Comments for Planning Application 24/00598/APP

Application Number: 24/00598/APP

Address: 12 Howard Avenue Aylesbury Buckinghamshire HP21 7HN

Proposal: Householder application for demolition of garage. Erection of part single and part two storey side and rear extensions

DETAILS
PROPOSED FLOOR / ROOF PLAN,
ELEVATIONS, BLOCK AND SITE
LOCATION PLANS

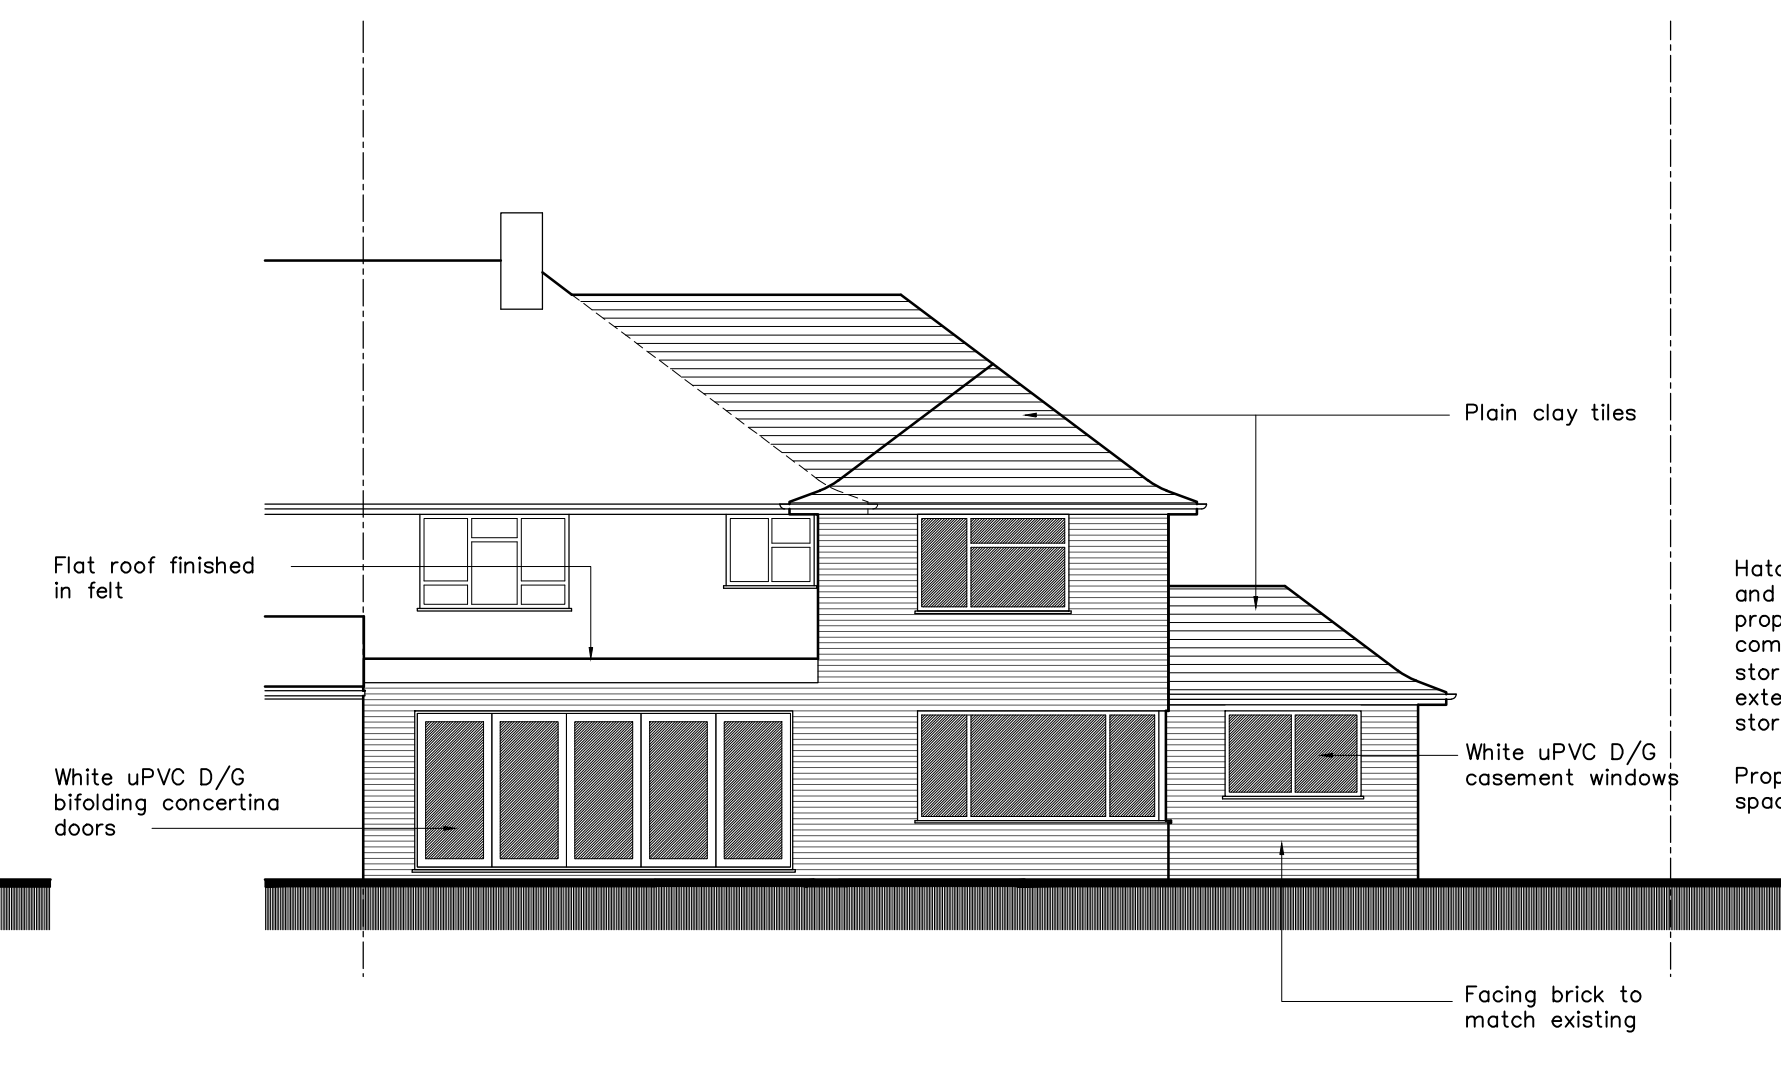
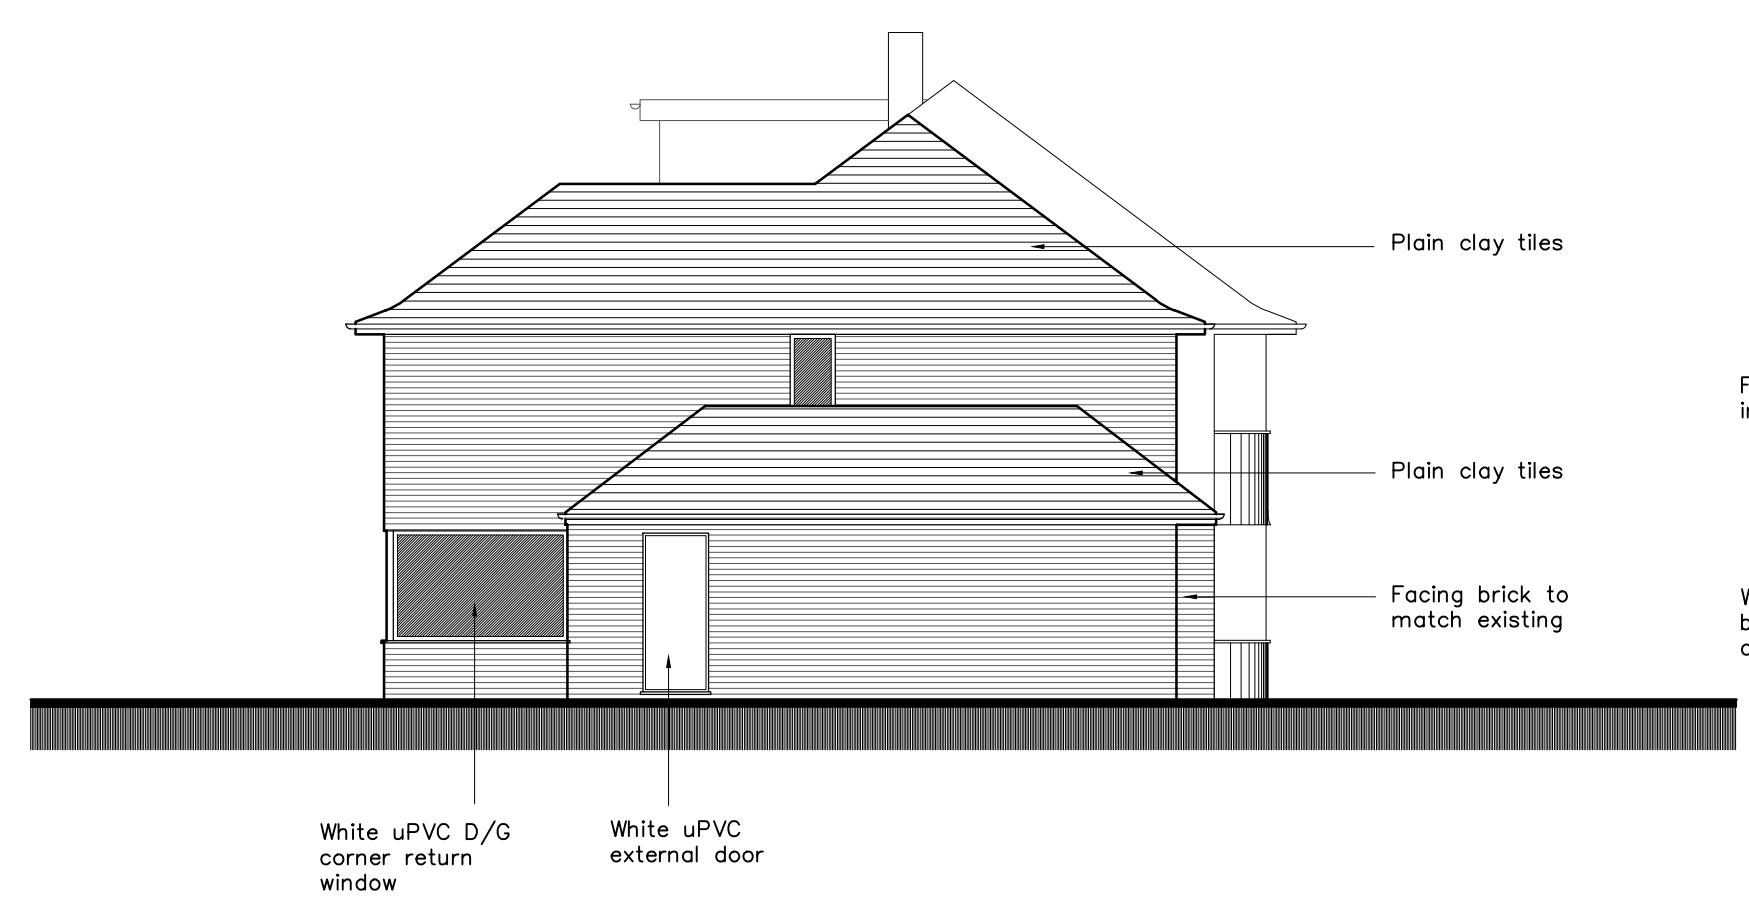
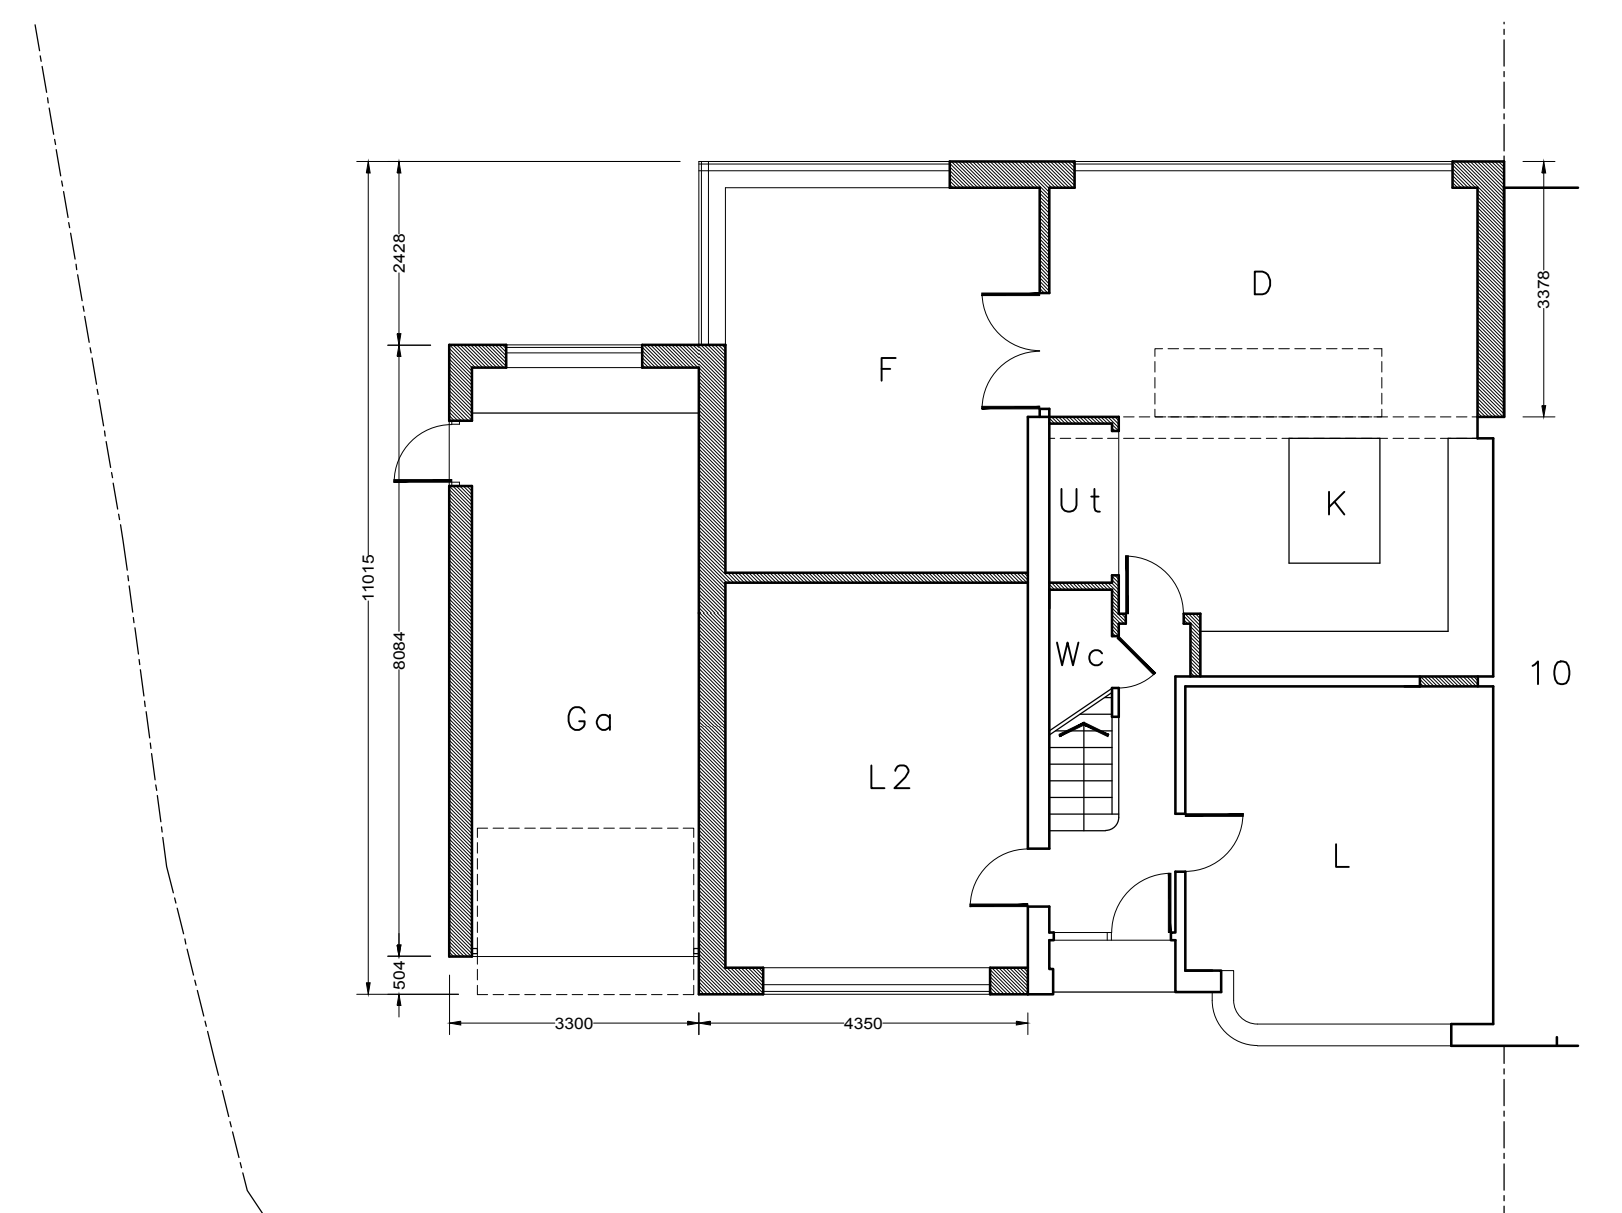
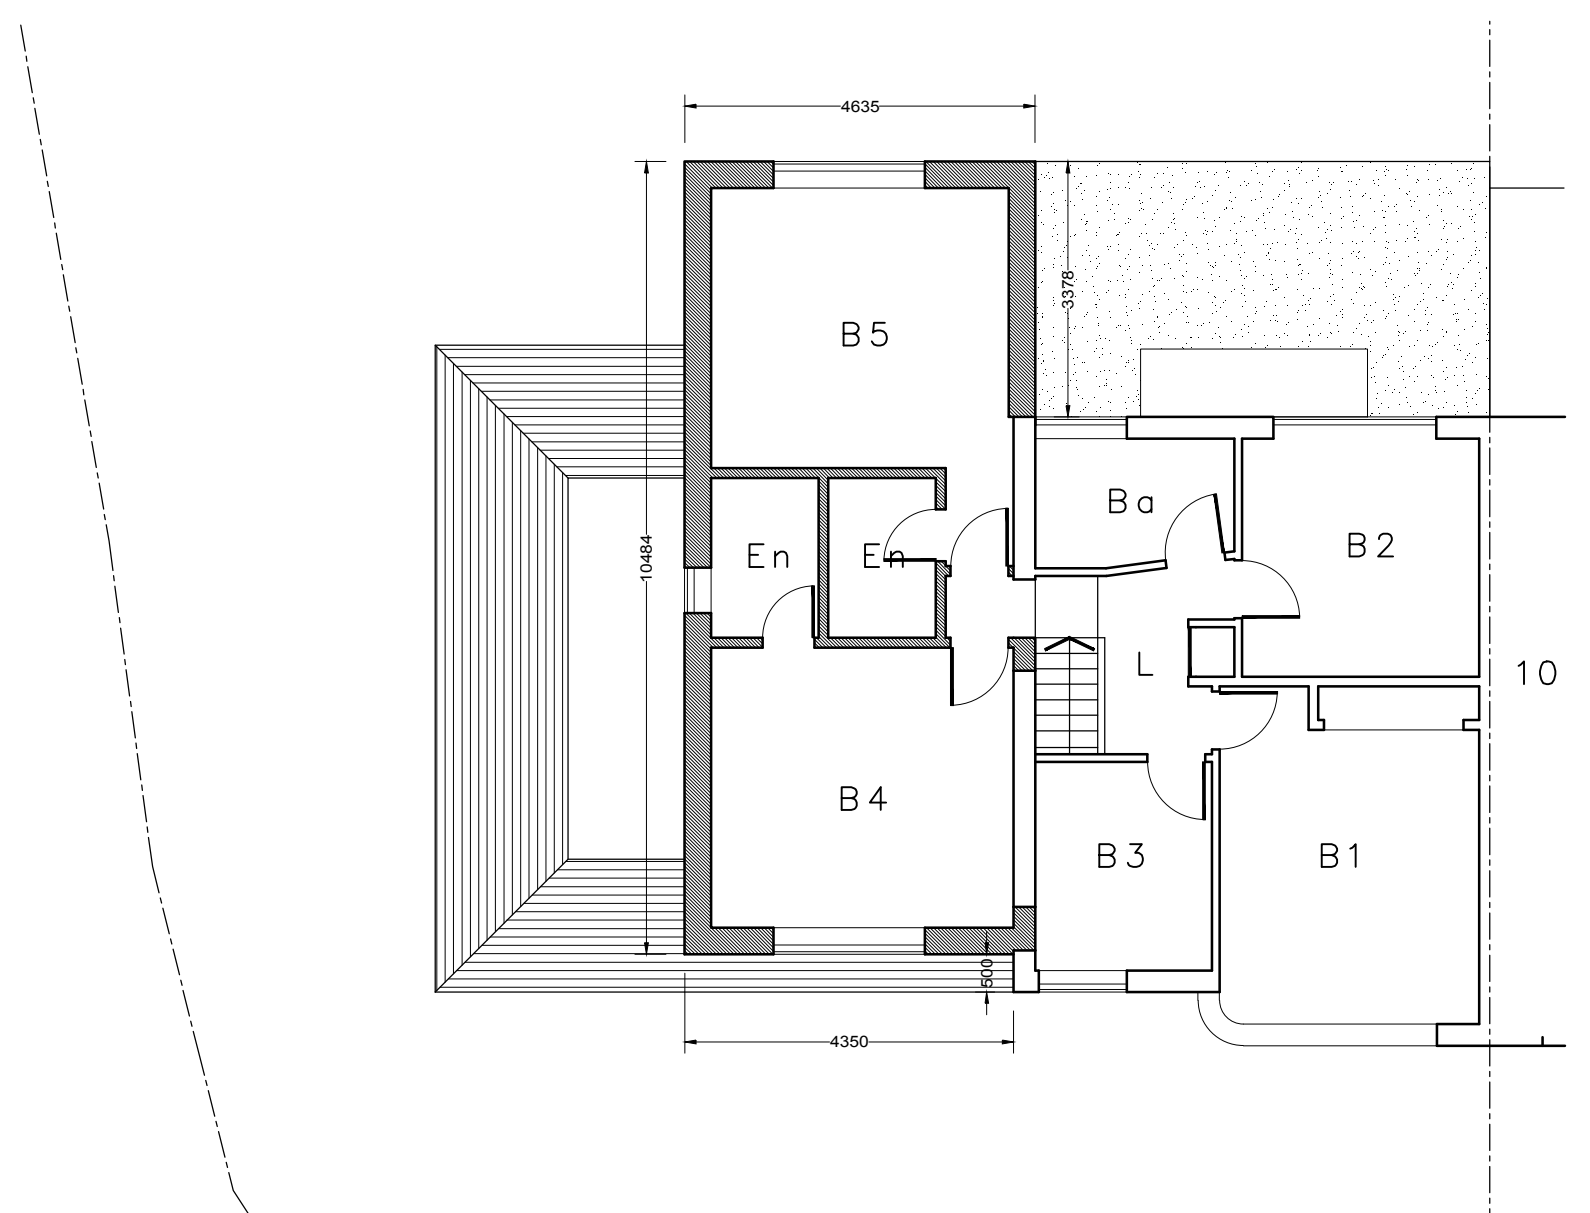
Comment: This addition has seemed to be done without any notification outside so residents can see this addition. We only found out by looking at it after letter to us on rear extension. We still object to a two story extension passed the original building line at rear side extension (light and sun will be reduced). Adding the garage will still obstruct the view for passing traffic, if this goes ahead then there should be less need for parking spaces at front of premises
